From: Katie Kurek [REDACTED]
Sent: 20 December 2018 16:03
To: Simon Davis
Cc: Planning.Responses
Subject: RE: Planning Consultation on FP/269/18/DOC

Description of Works: Approval of details reserved by condition imposed under ref
FP/180/17/PL relating to Condition Nos 6, 7, 8 and 12.

TO:	Arun District Council FAO: Simon Davis
FROM:	Highways, WSCC
DATE:	20 th December 2018
LOCATION:	84, Flansham Lane, Bognor Regis, PO22 6AH
SUBJECT:	FP/269/18/DOC Approval of details reserved by condition imposed under ref FP/180/17/PL relating to Condition Nos 6, 7, 8 and 12.
RECOMMENDATION:	☒ Advice ☐ Objection ☐ Modification ☐ No Objection ☐ More Information ☐ Refusal
S106 CONTRIBUTION TOTAL:	£N/A

DRAWING
**PROPOSED
LANDSCAPE PLAN**

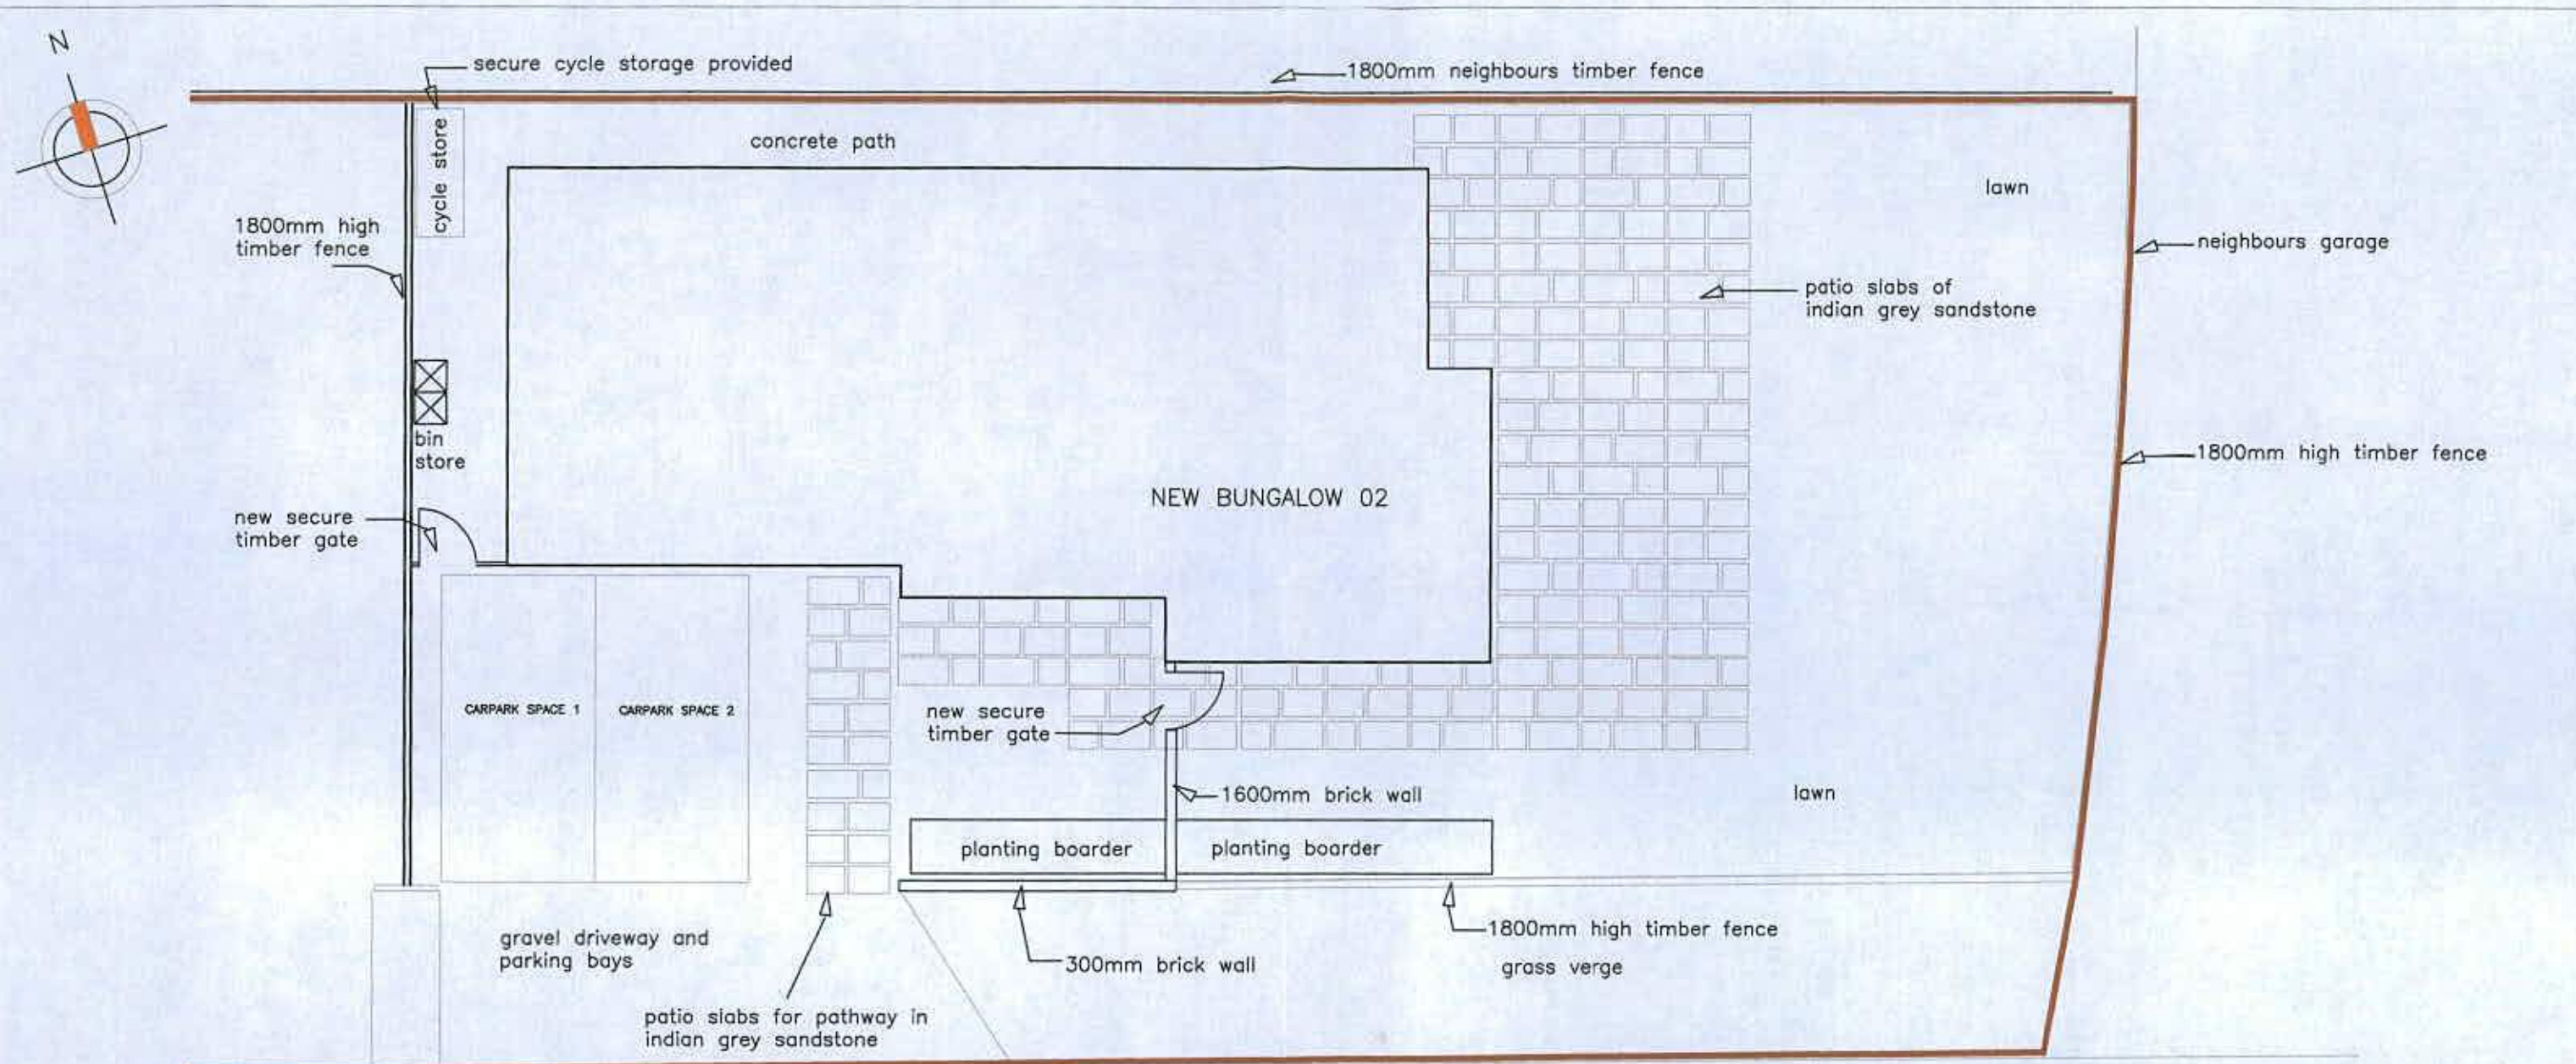
Only one of the proposed dwellings has been built and the plans indicate the location of a secure bicycle store to the west of the dwelling. The plans and details pertaining to the condition are acceptable.
